Recommendation Report for Planning Permission for Works or Extension to a Dwelling

REF NO: LU/72/20/HH

LOCATION: 29 Linnet Close
Littlehampton
BN17 7GW

PROPOSAL: Single storey rear extension.

PROPOSED ELEVATIONS 1:100

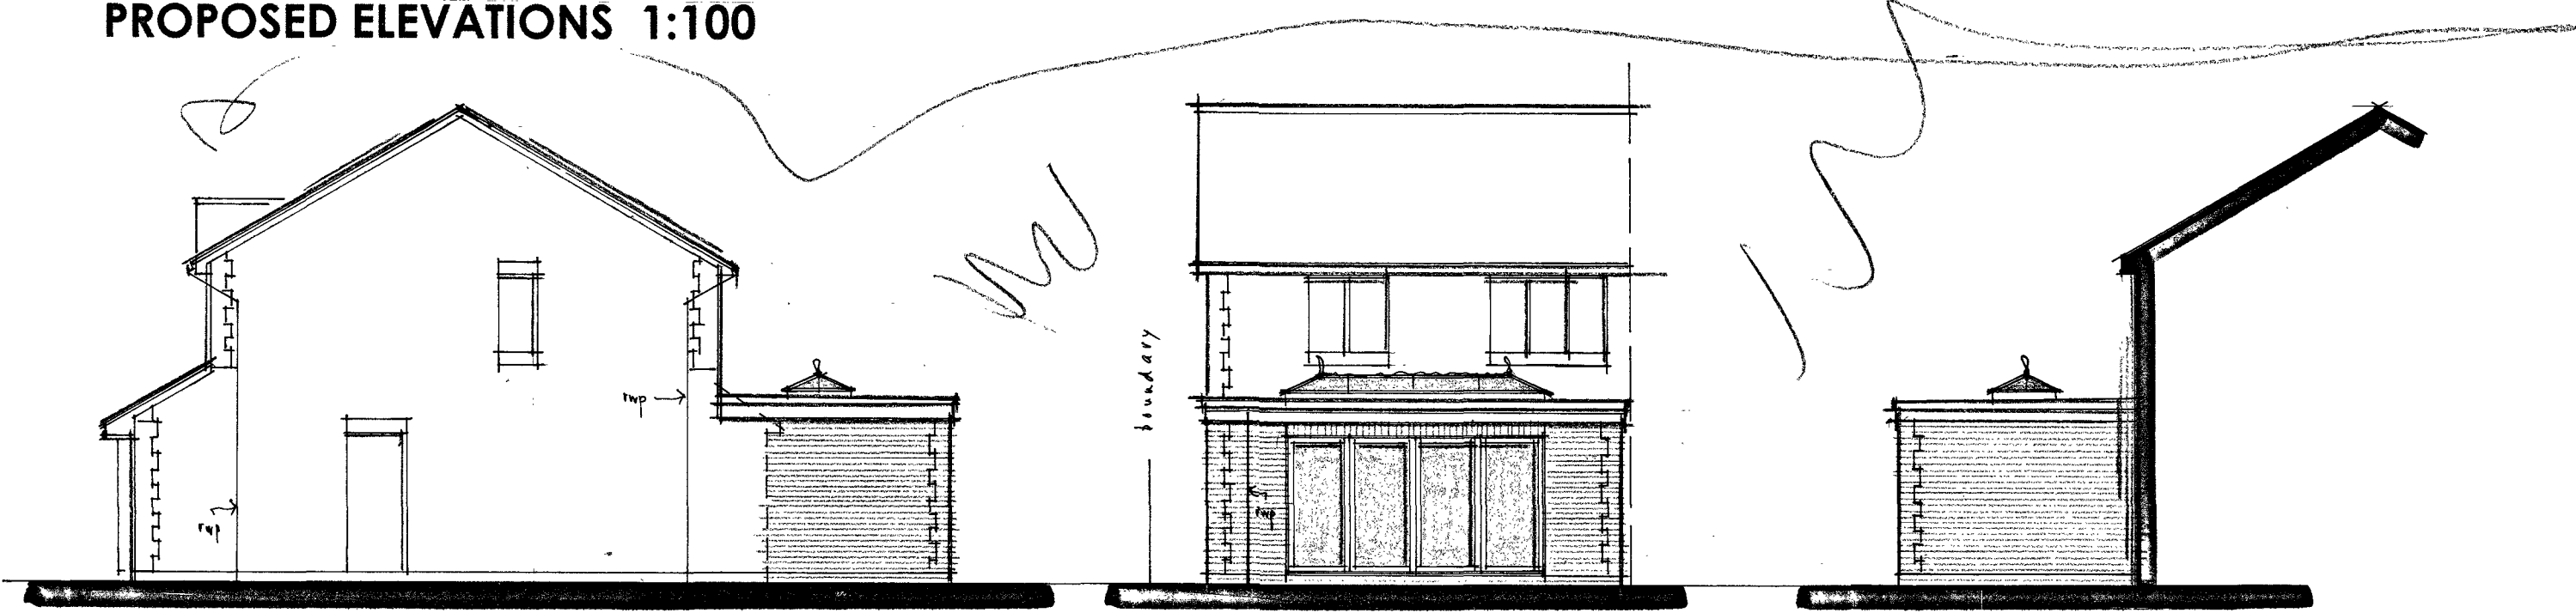
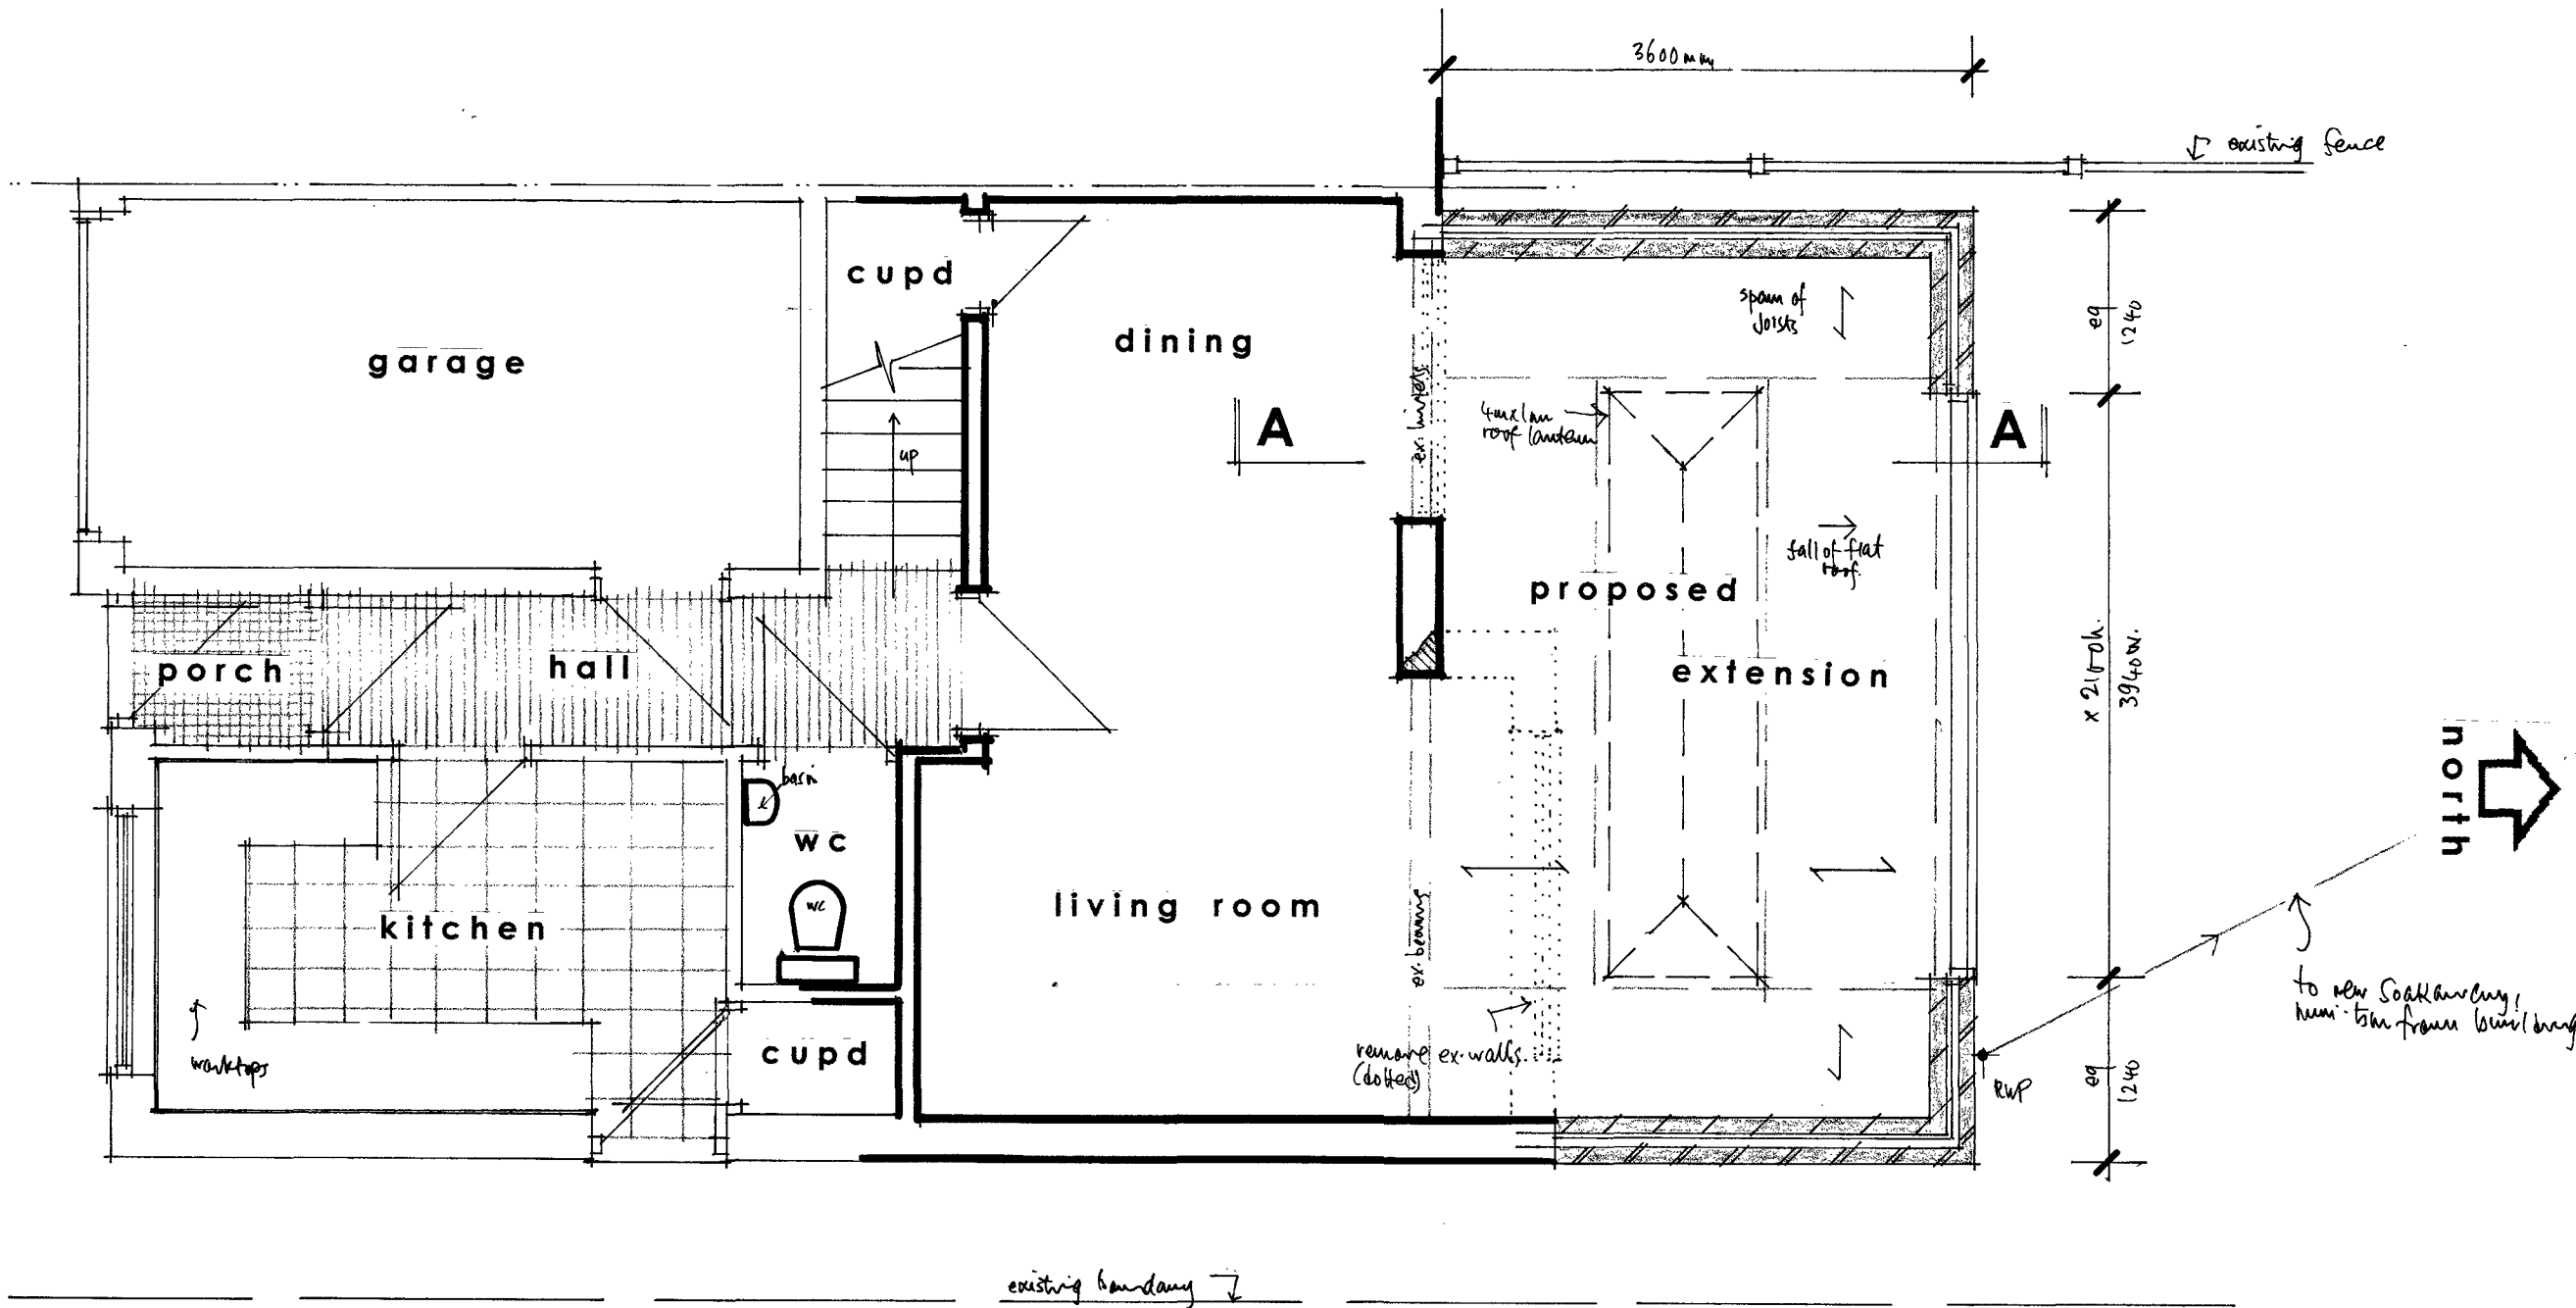
The extension has a maximum height of 3.3m from ground level, however, this is as a result of a roof lantern, with the majority of the extension being at a height of 2.8m. The development is approximately 4.15m lower than the ridge height of the host dwelling, and it appears subservient to, and well integrated with dwelling.
